Re: Formal Objection to SSD-82900461 – Concept Proposal for a Residential Flat Building with In-fill Affordable Housing at 11-19 Middle Harbour Road, Lindfield

I write to formally Object to **SSD-82900461** Concept Proposal for proposed residential flat building with in-fill at **11-19 Middle Harbour Road, Lindfield**, on multiple grounds related to non-compliance with statutory thresholds, planning controls, heritage conservation, environmental impacts, and community consultation deficiencies.

Figure 2 Proposed Height Banket Diagram.

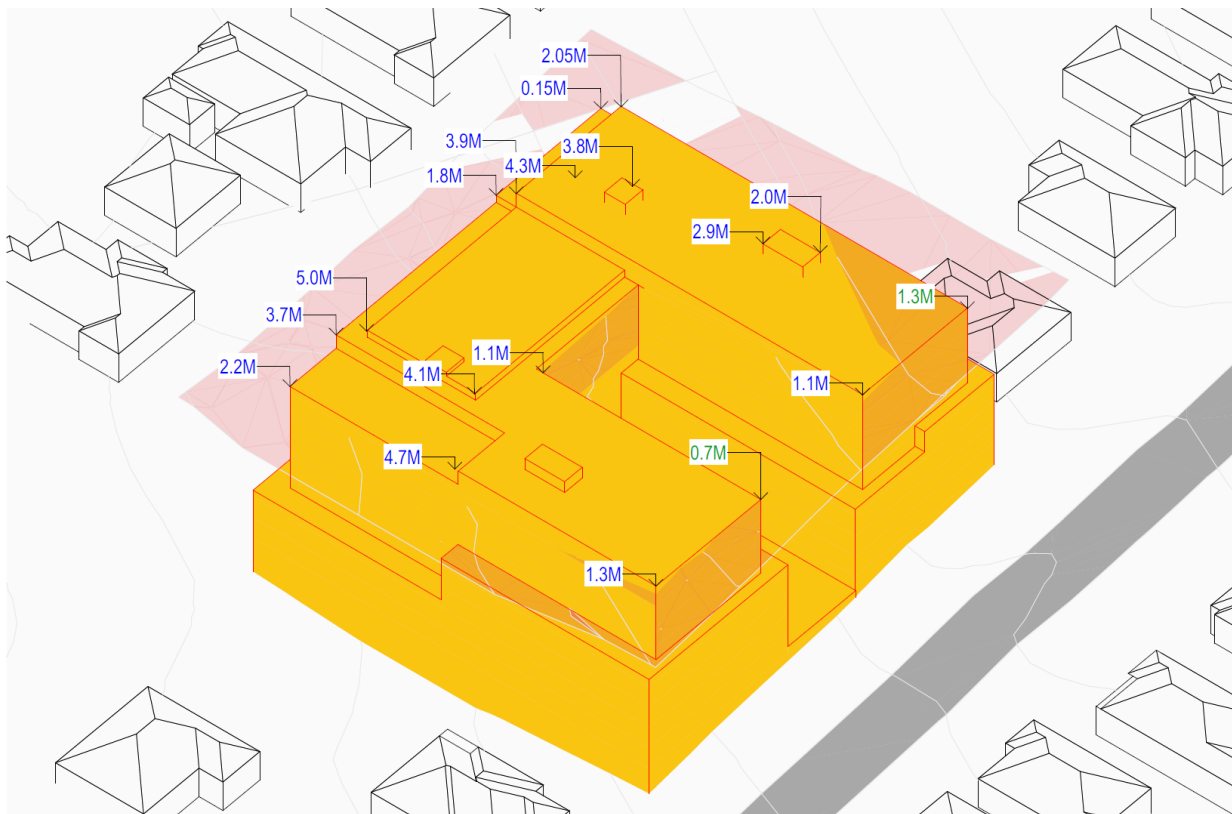
The proposed maximum height of 33.6 metres breaches the 28.6-metre limit by 5 metres (17.48%). This excessive height harms local character, amenity, and visual harmony, causing overshadowing and visual intrusion.

The applicant's use of Housing SEPP "bonus" provisions to exceed base height is unjustified and conflicts with local planning controls and the Council's Preferred Housing Scenario.

This major breach must be refused.

DA400

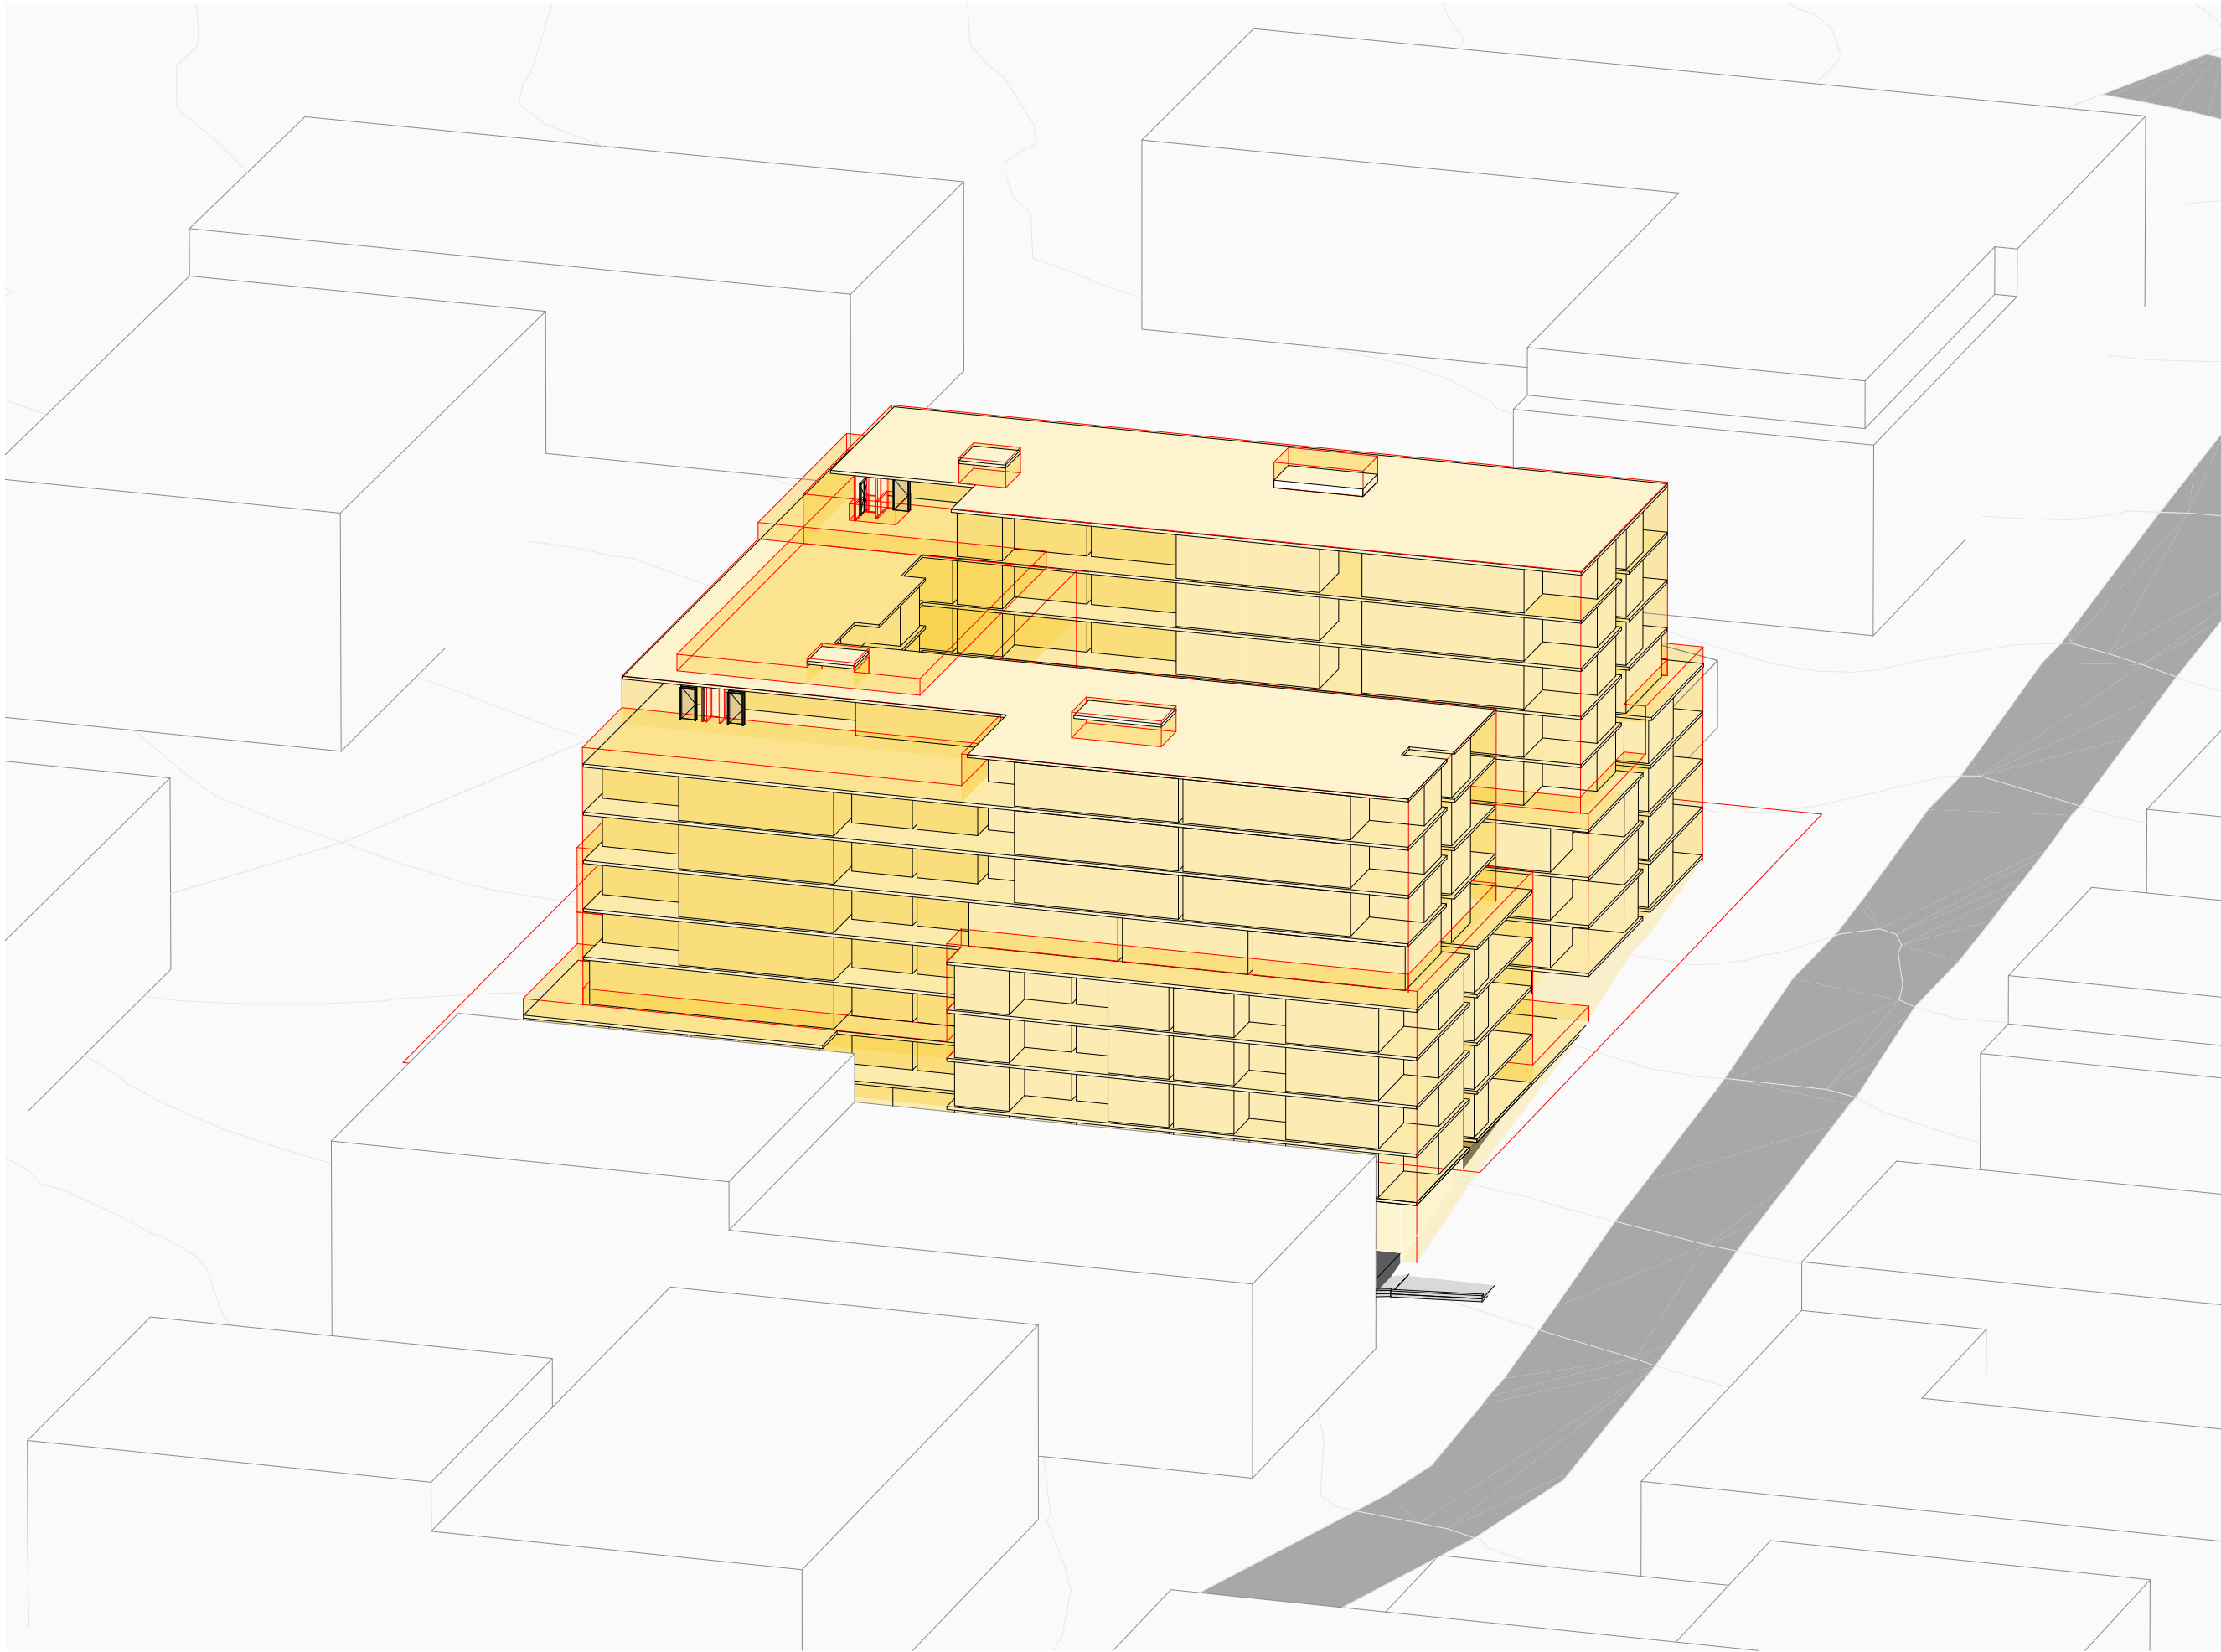
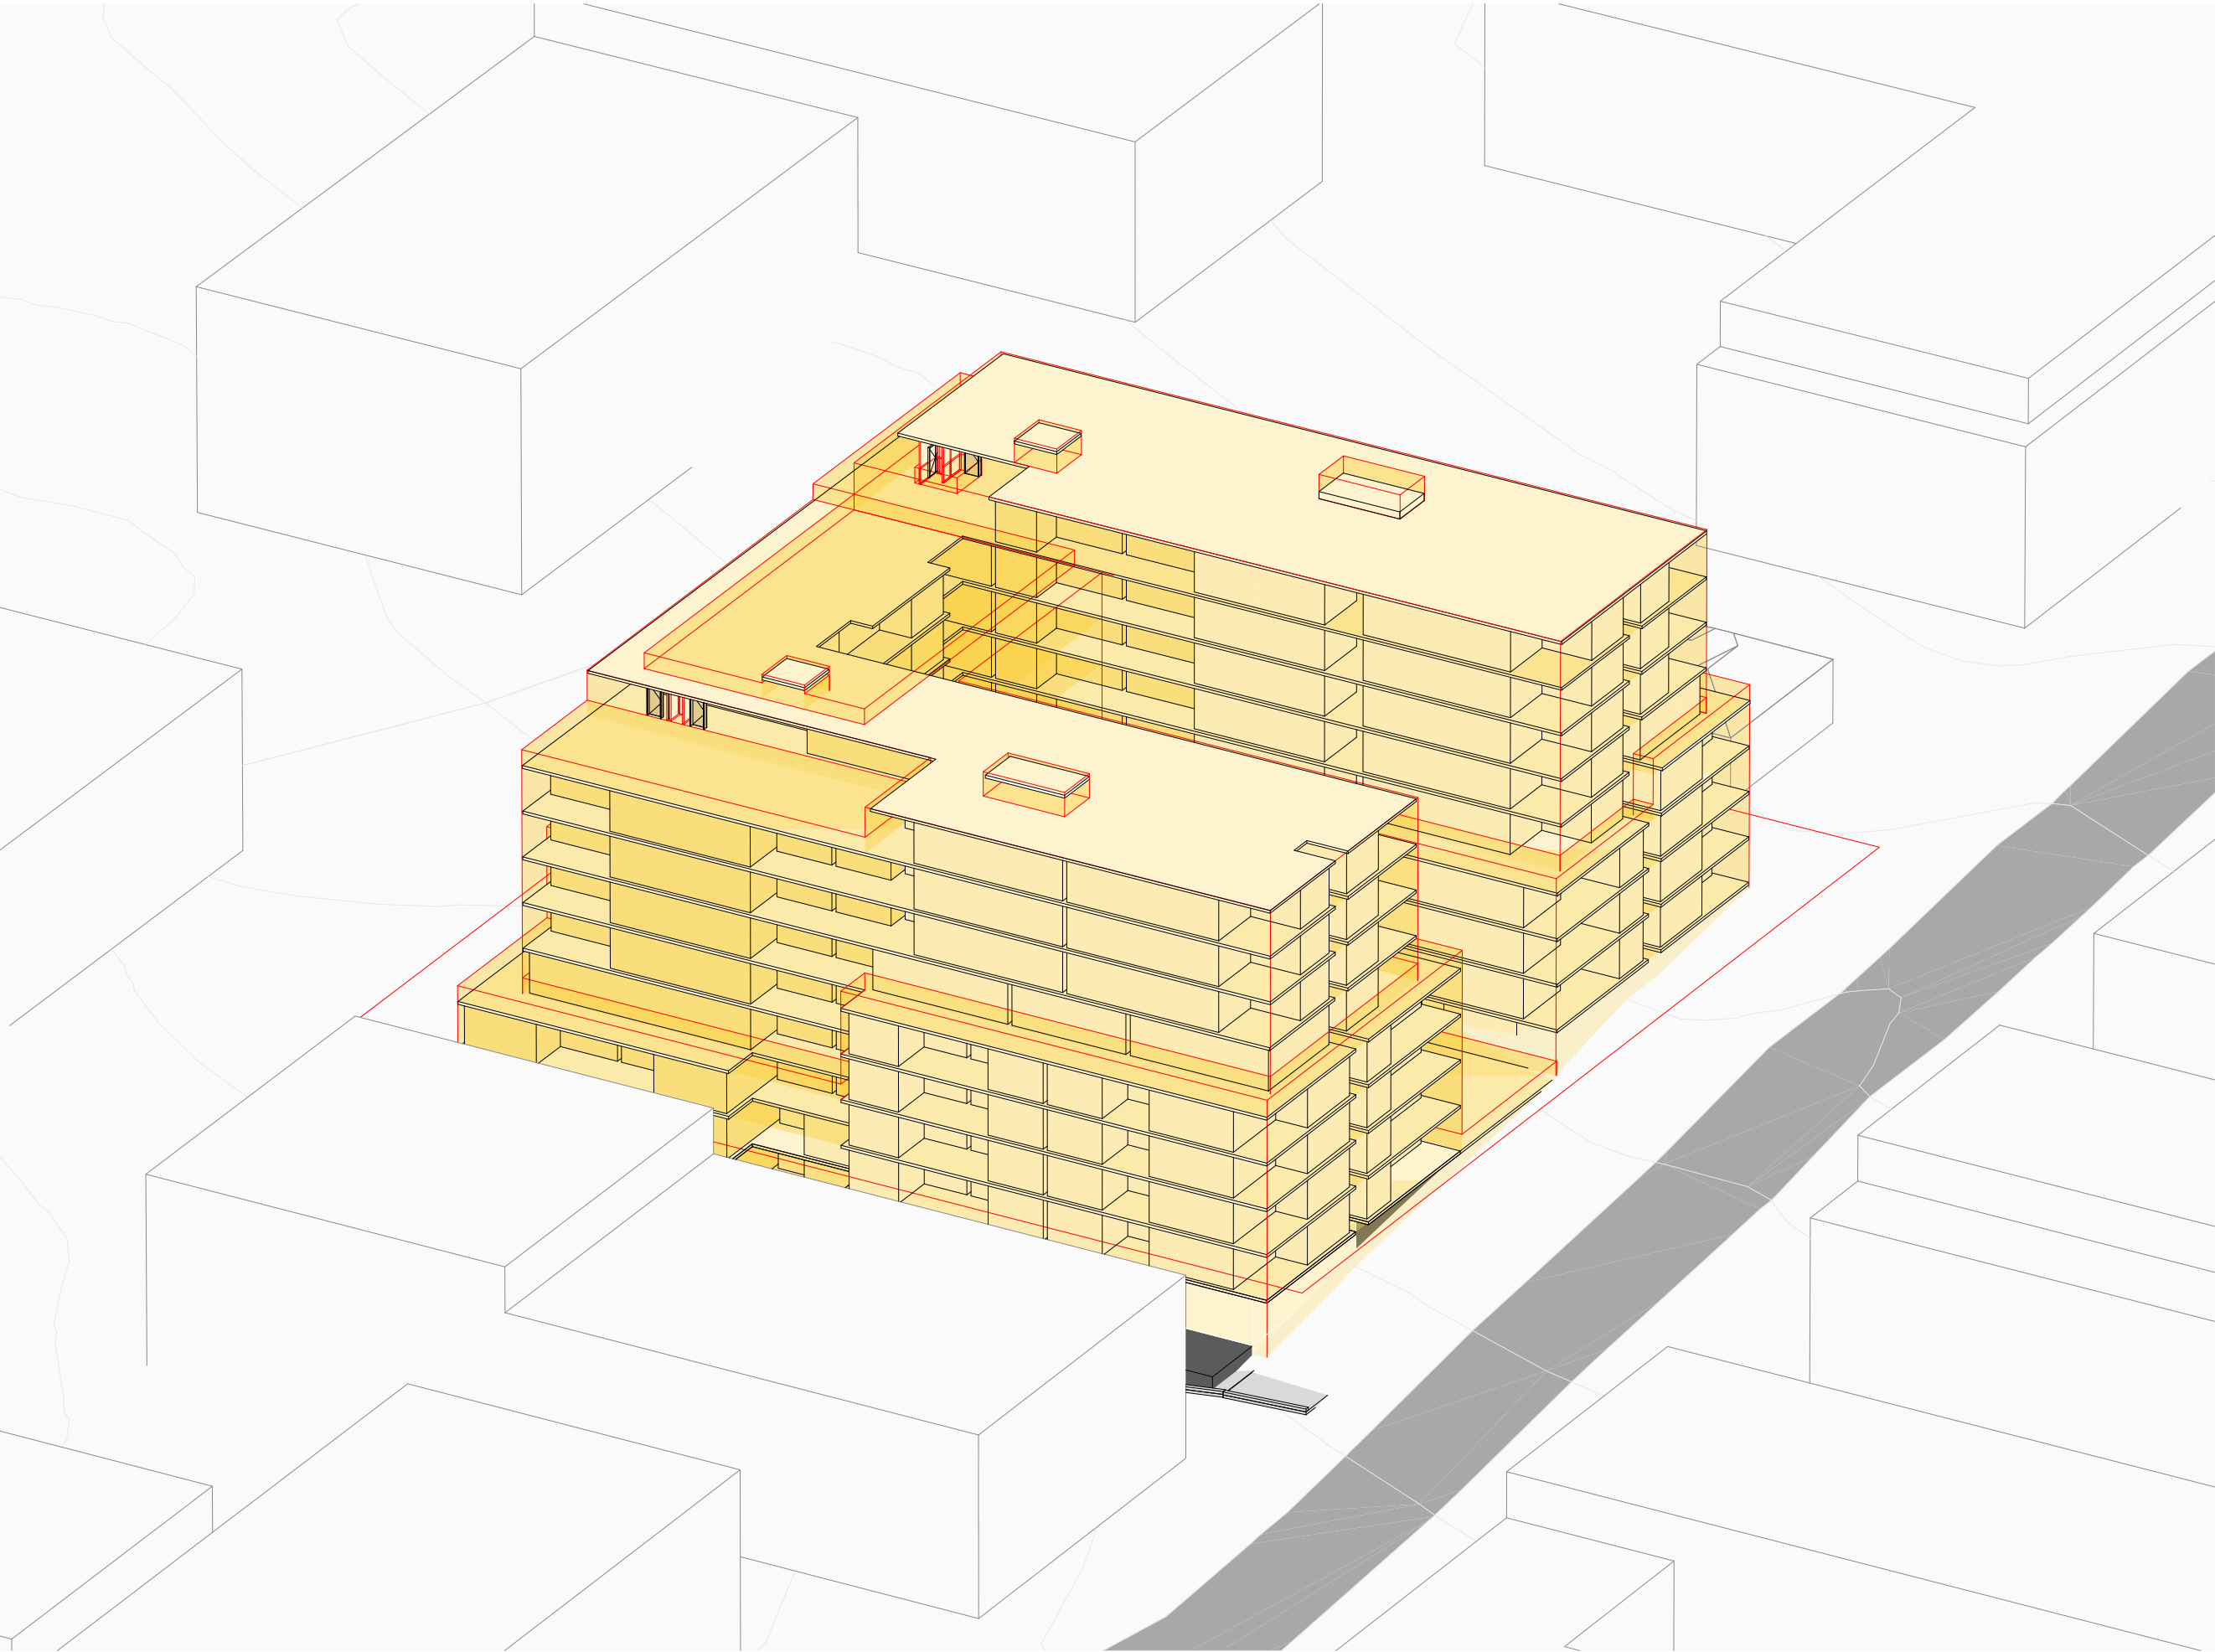
The application omits detailed, compliant sunlight and shadow diagrams as required by the Ku-ring-gai DCP and relevant SEPPs. This prevents transparent and proper assessment of overshadowing impacts on neighbouring properties.
